**Proposal:** Discharge of condition 6 (segregated pedestrian and cycle path) of 21/03177/F

- 2.1. This submission seeks to discharge condition 6 of 21/03177/F, which relates to the details of the segregated pedestrian/cycle path.

Drawing Title  
**S278 WORKS (Phase 3)**  
 General Arrangement

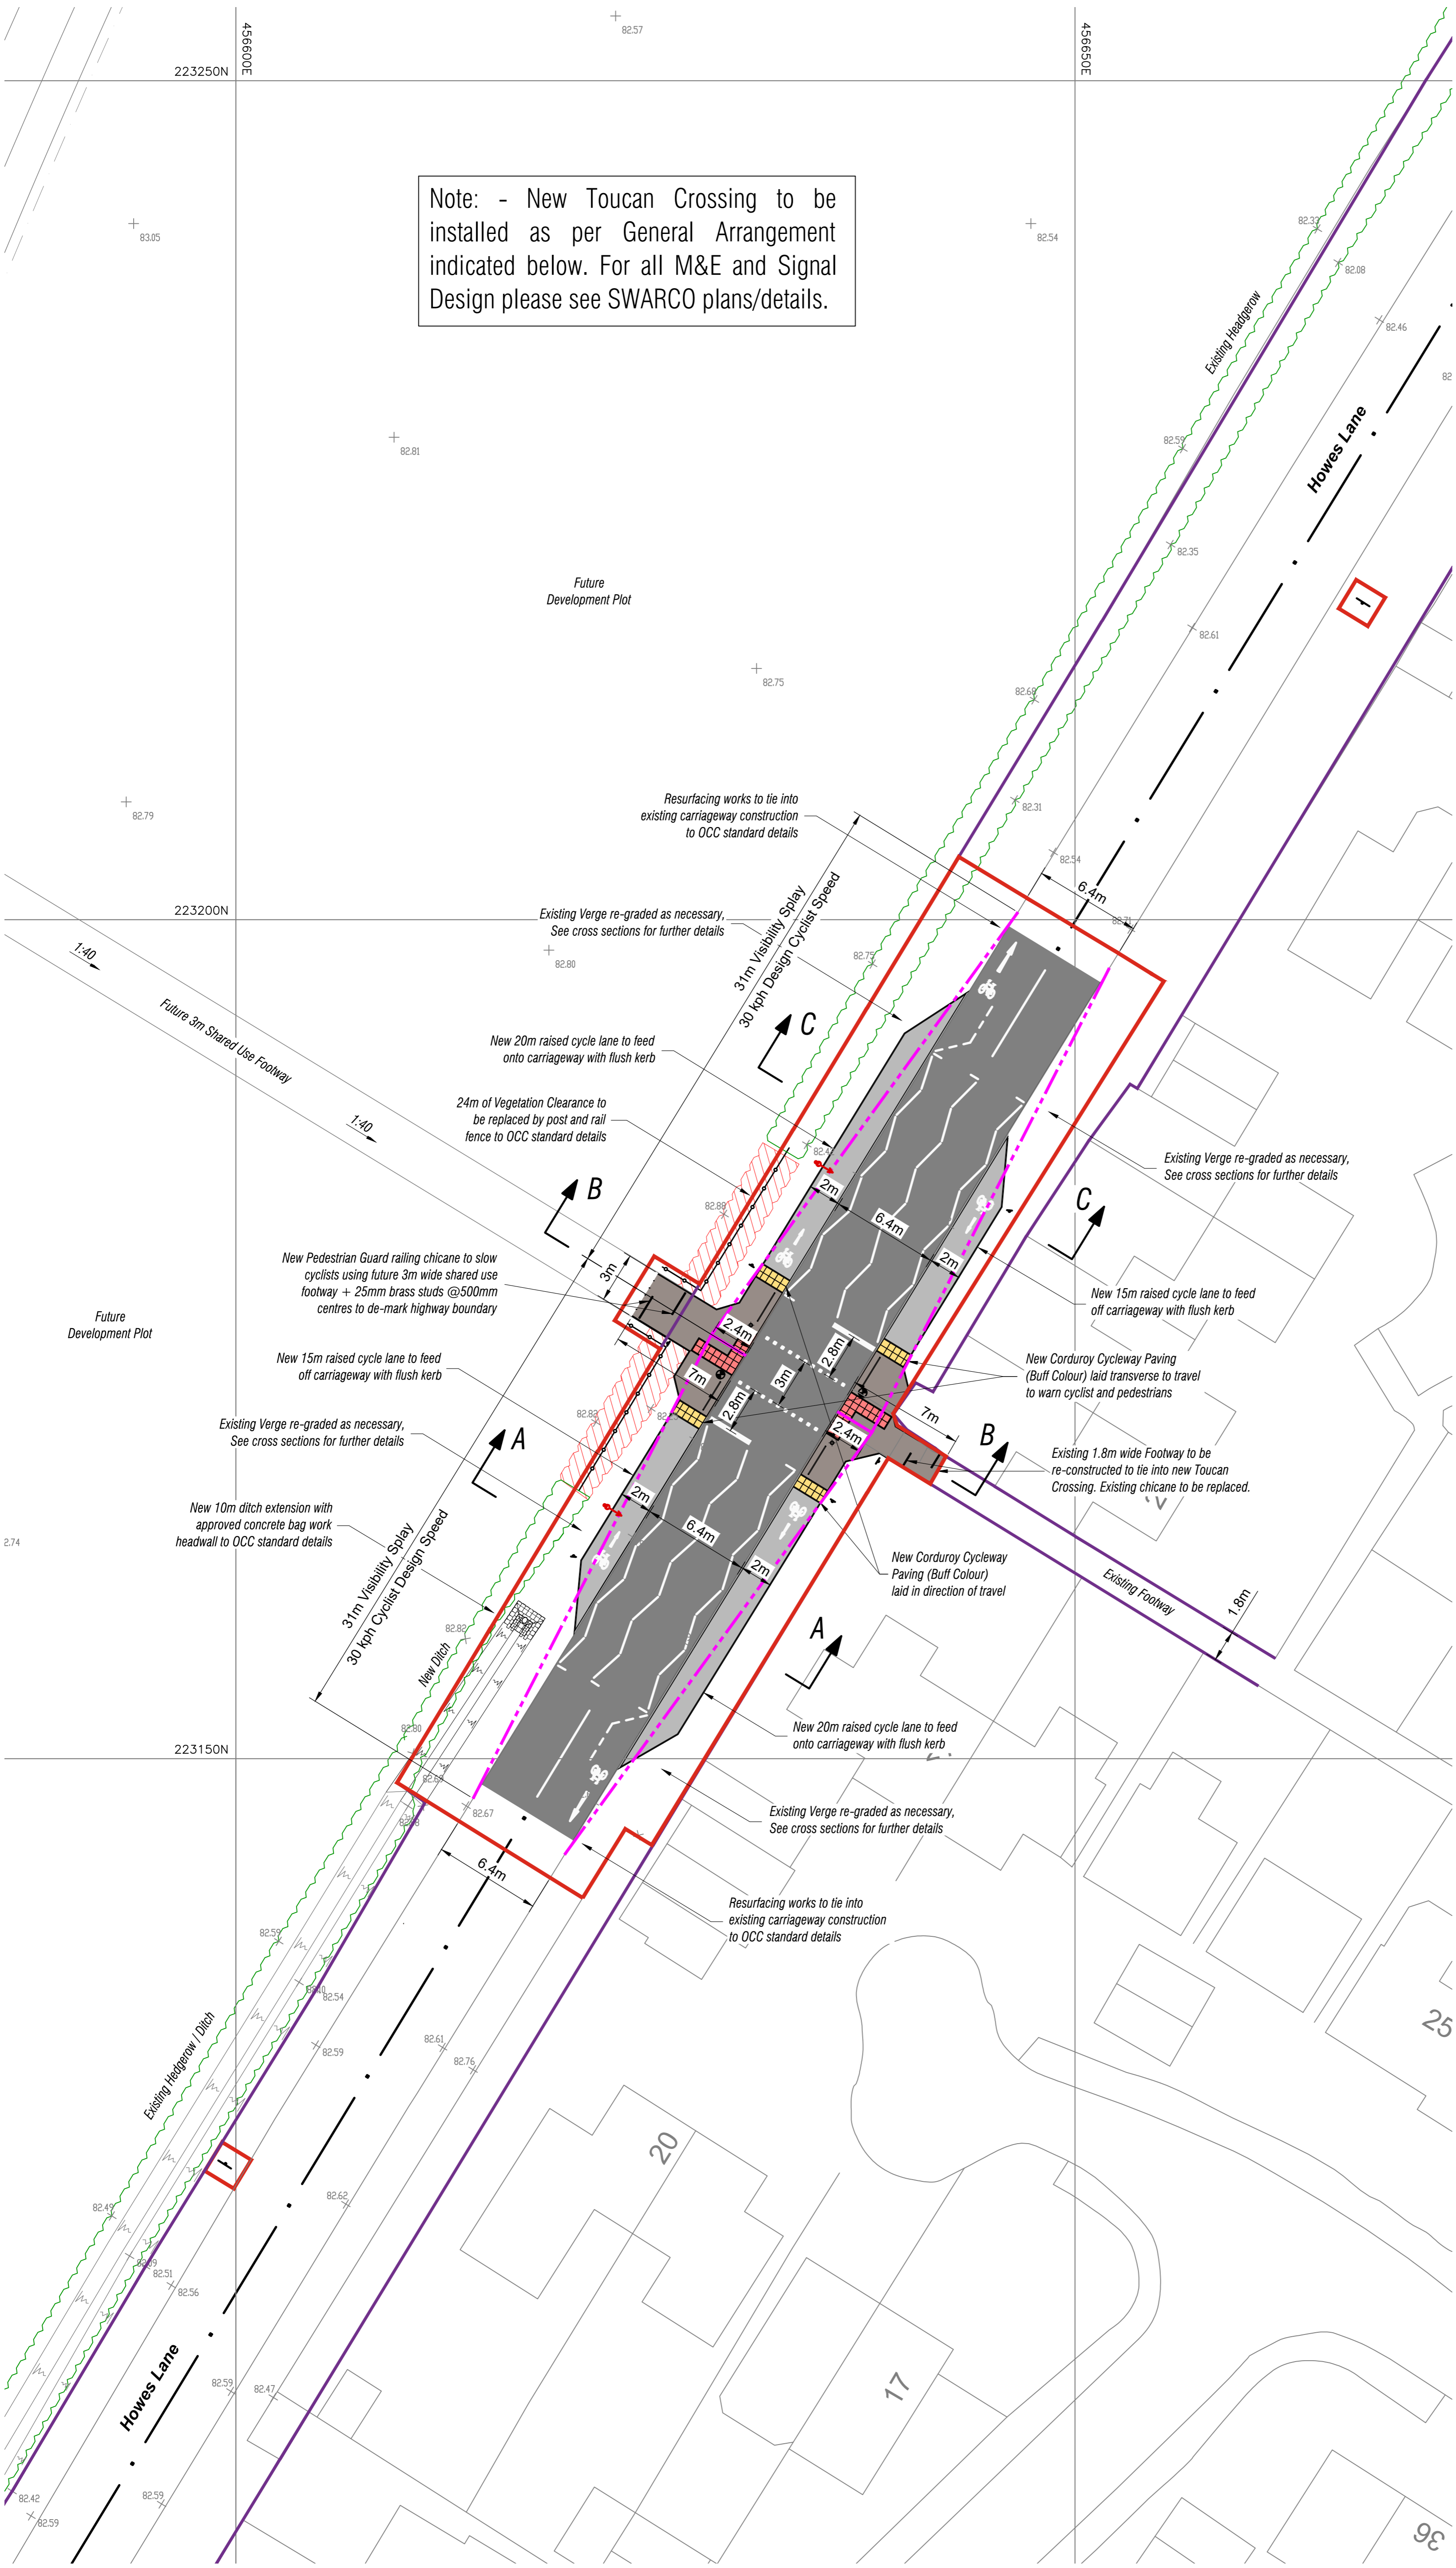
- 6.2. The LHA have reviewed the information and are content with the details. The path will link to a new toucan crossing on Howes Lane, which is the subject of a S278 application to OCC, whereby the detail will be agreed. It's assumed that this path will be part of a S38 submission, whereby the technical detail will be agreed. However, it is acceptable in principle. The path is proposed as a 3m wide shared use path, which is in line with the planning permission and acceptable here as in the longer term the path will have a relatively low level of usage, the main route being provided
